Observations By:	KC, Highways Development Management
Application No.	2021/91795
Proposed Development:	Erection of 7 dwellings with formation of associated access and parking
Location:	Manashay Cottage, Upper Brow Road, Paddock, Huddersfield, HD1 4UP
OS Map Reference	SE 412412.3245 416093.5407
Applicant/Agent:	Northern Design Partnership
Class:	Minor Developments

**Consultation Response from KC,  
 Highways Development Management**
**2021/91795 Manashay Cottage, Upper Brow Road, Paddock, Huddersfield, HD1 4UP**
**Erection of 7 dwellings with formation of associated access and parking**
**Date Responded:  
 26/05/2021**
**Responding Officer: Mark  
 Berry**
**Responding Ref: 5-1SW-8**

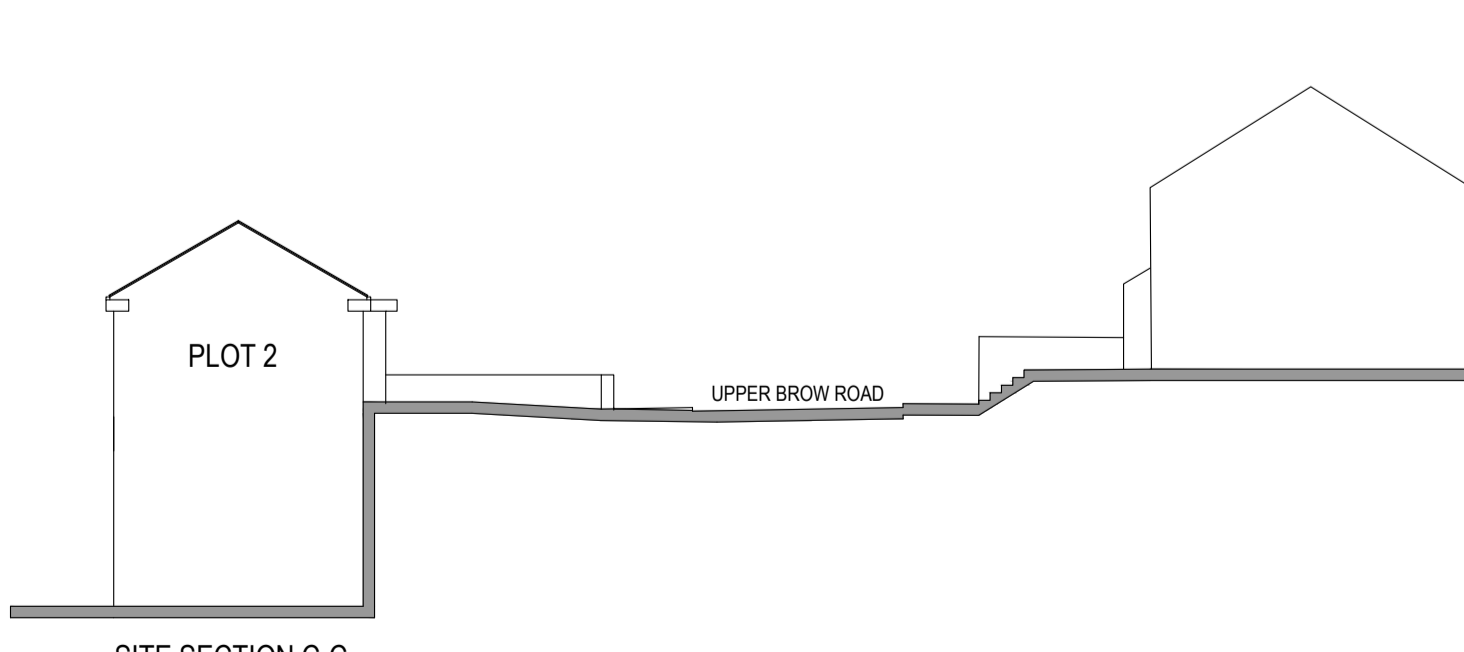
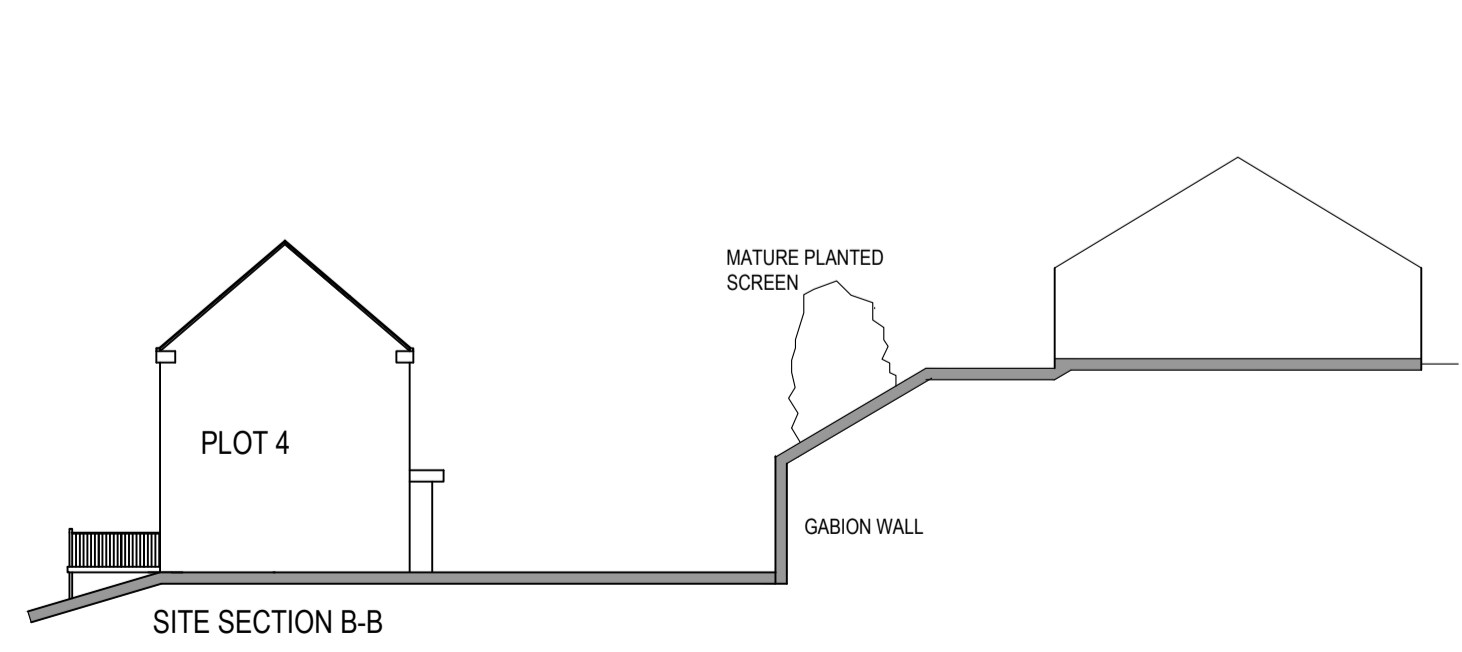
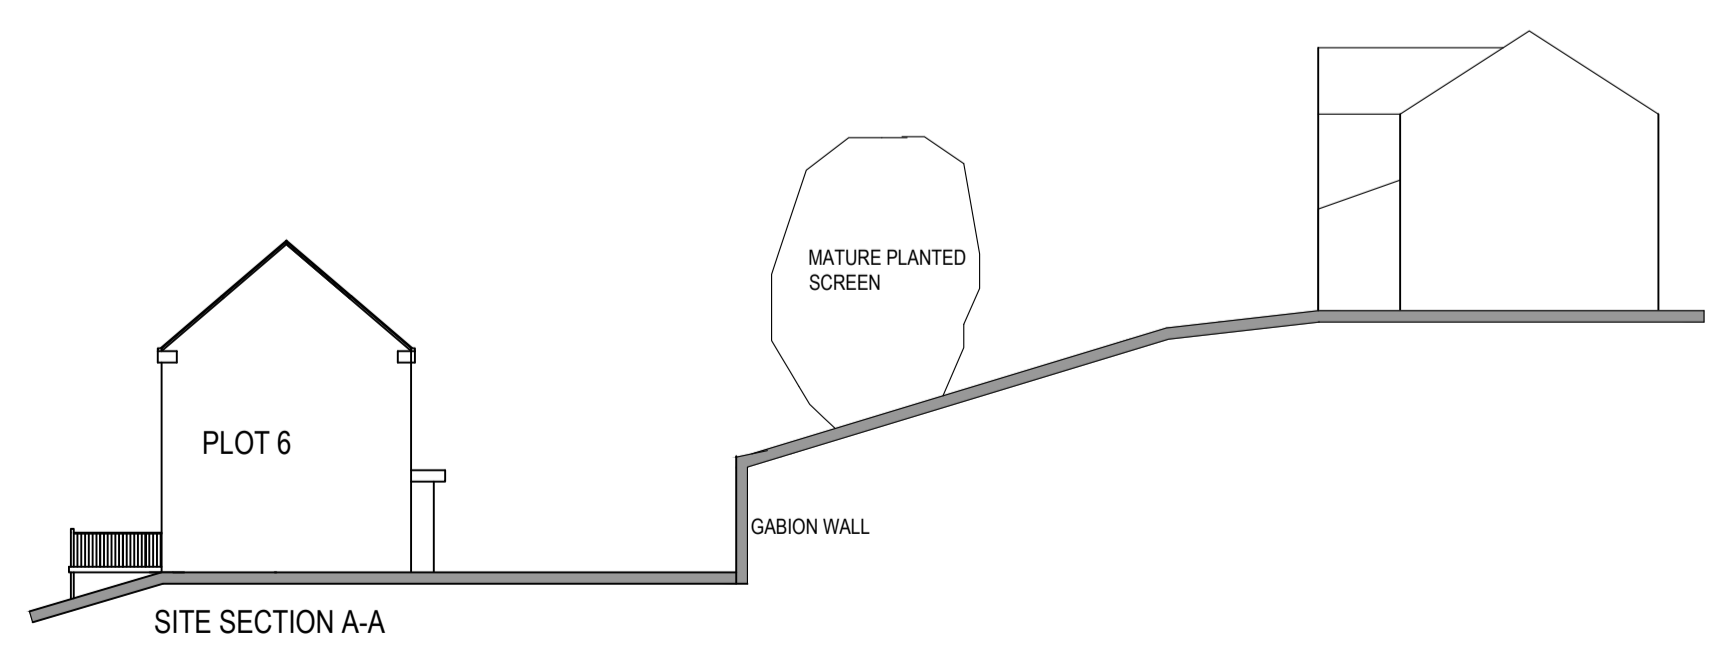
HDM do have concerns regarding the proposal for plots 4 to 6 as follows:

- 1, The full extent of the access from Upper Brow Road is not shown on the plans and the sight lines from the access onto Upper Brow Road are not shown.
- 2 The width of the proposed driveway is not dimensioned and appears narrow the rear boundaries of plots 1 and 2. Can this dimension be clarified. A minimum of 4.5m is recommended to allow 2 vehicles to pass.
- 3, The existing plot and plot 7 are shown to have 3 off-street parking spaces, plot 6 is shown to have 4 off-street parking spaces and 2 visitor parking spaces are shown. No parking is shown to plots 4 and 5.
